Appendix J: Visual Impact Peer Review

Rye Park Wind Farm Modification 1 Peer Review of VIA

09 March 2020

Figure 12 - Effect of distance on views toward consented RPWF and Mod 1 wind turbines at 2.7km and 4km

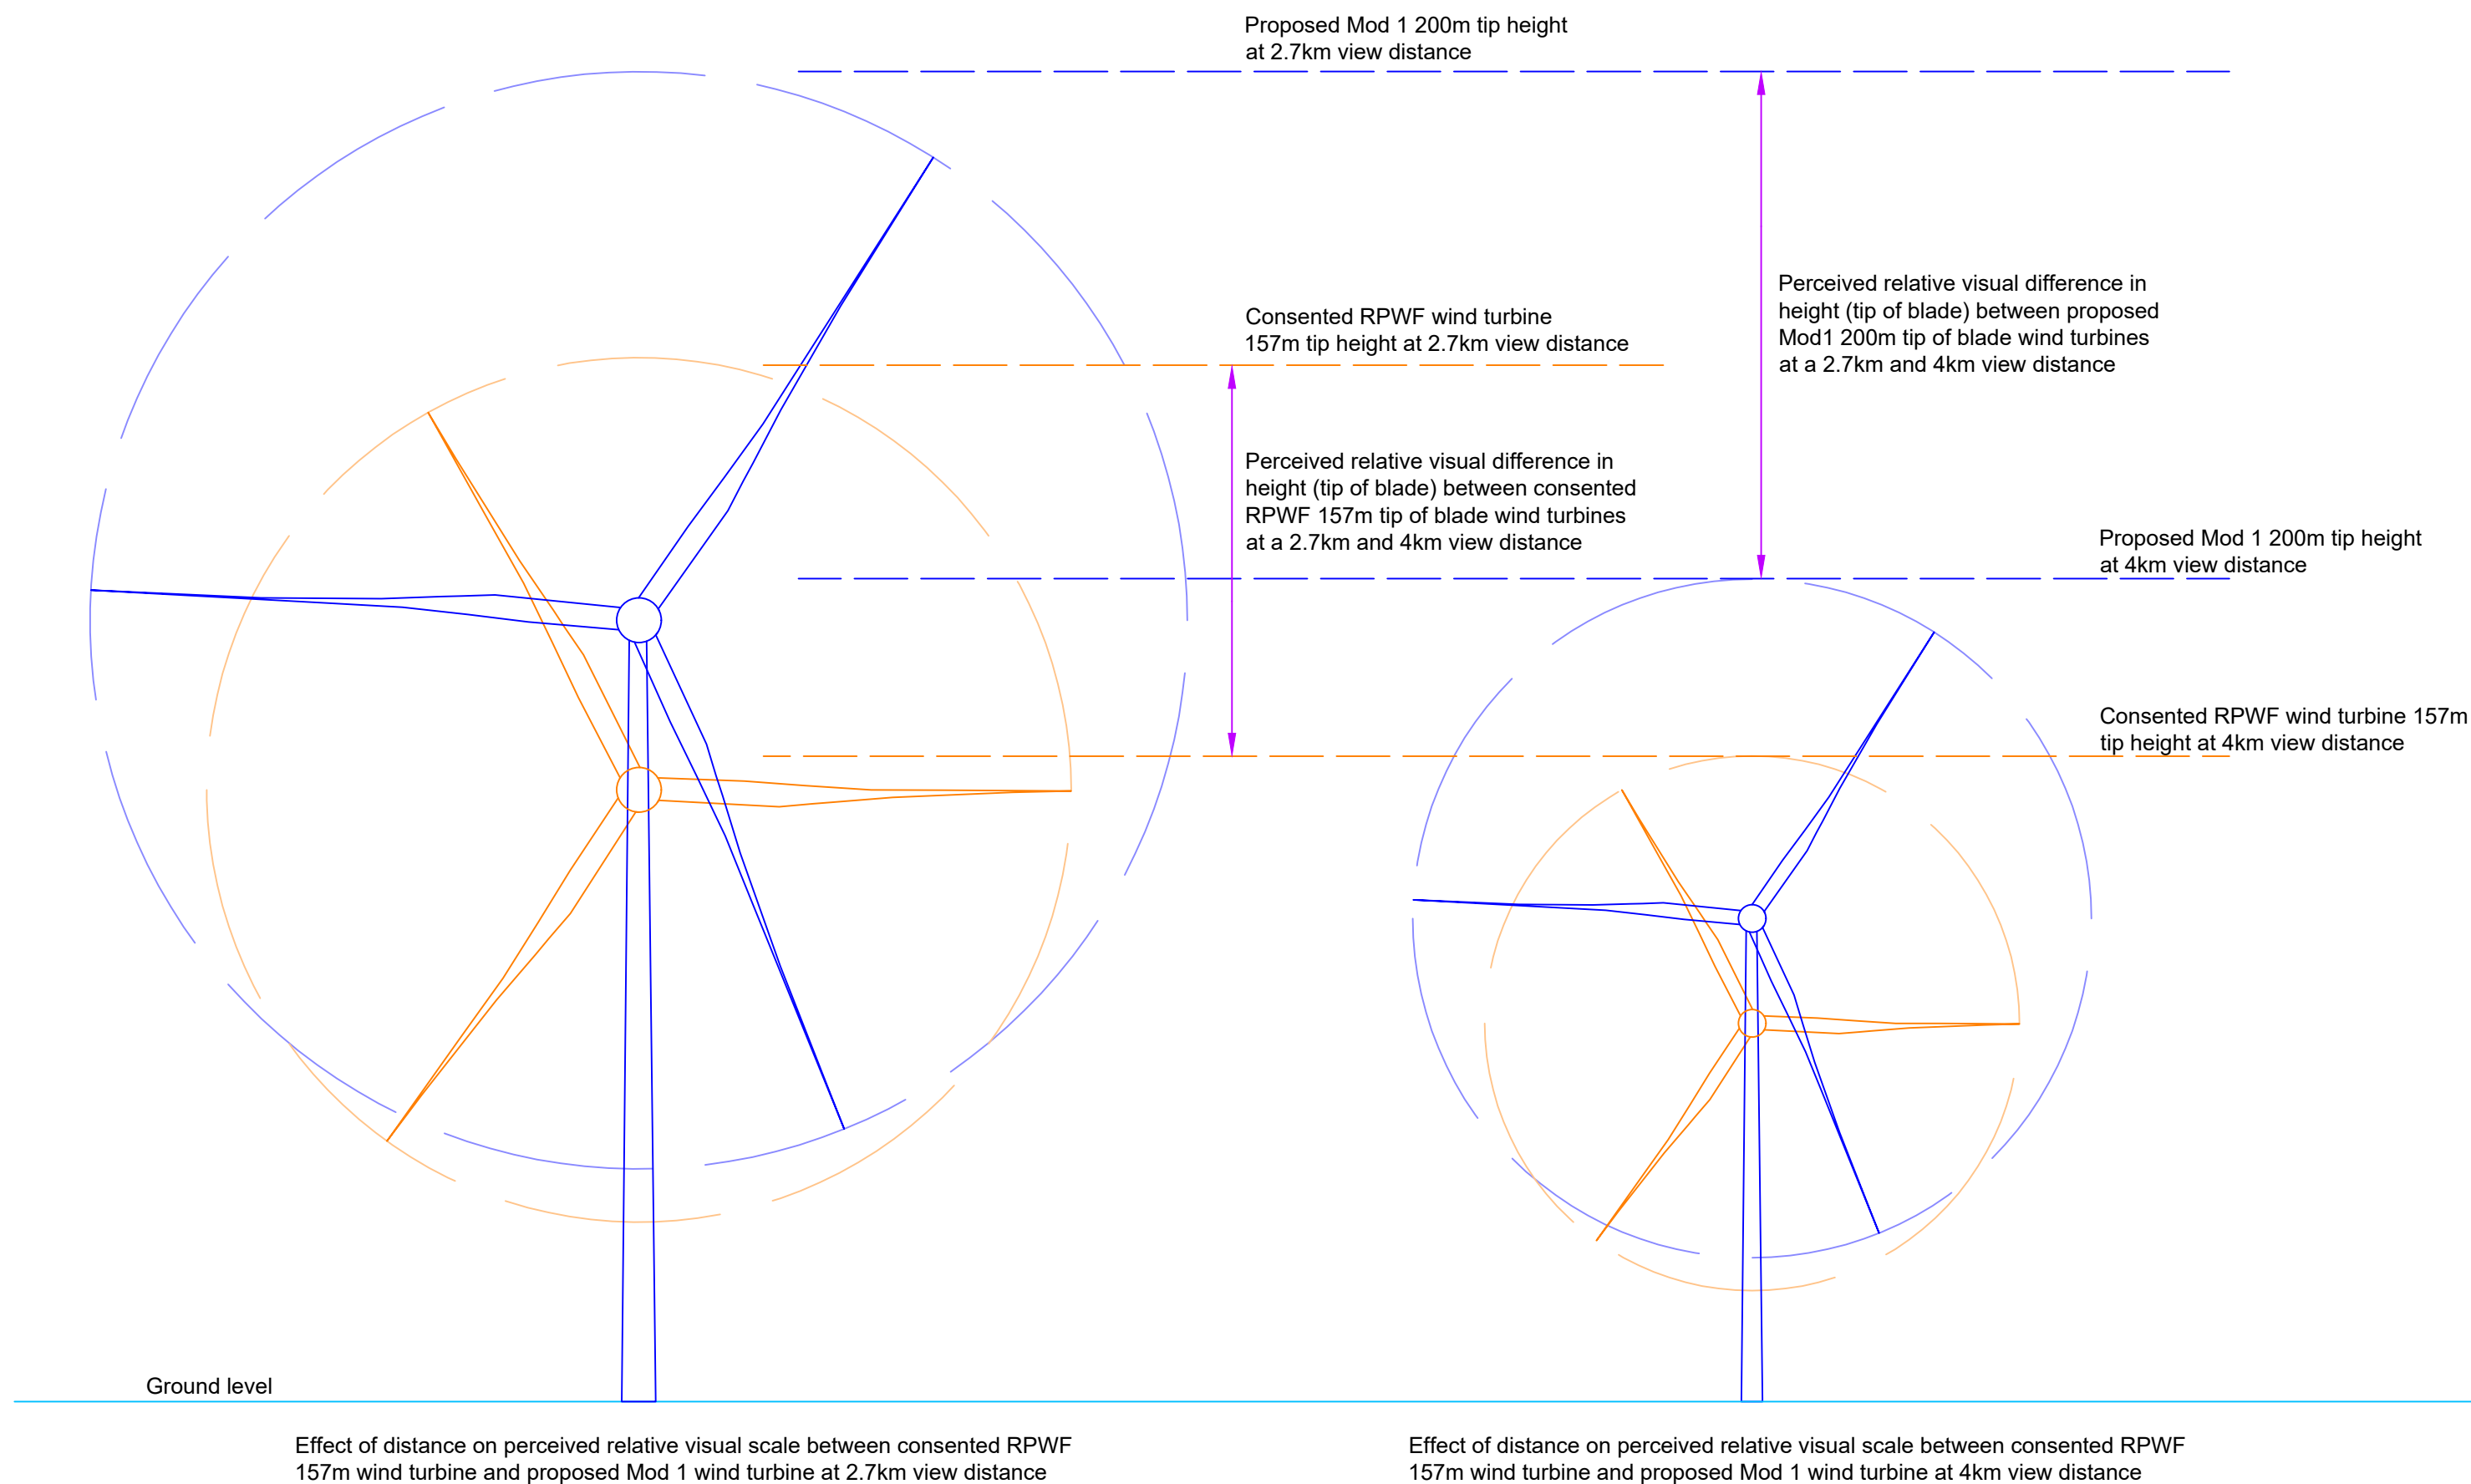
12. The VIA demonstrates graphically, through scale and the visual magnitude at distance, the comparison between the approved and Mod 1 turbines which informs the conclusions of effect on each receiver in Table 5. The magnitude assessment is undertaken at distances of 2.7km and 4km which is reference to Figure 5. Visual Magnitude Thresholds for Visual Assessment in The Bulletin.
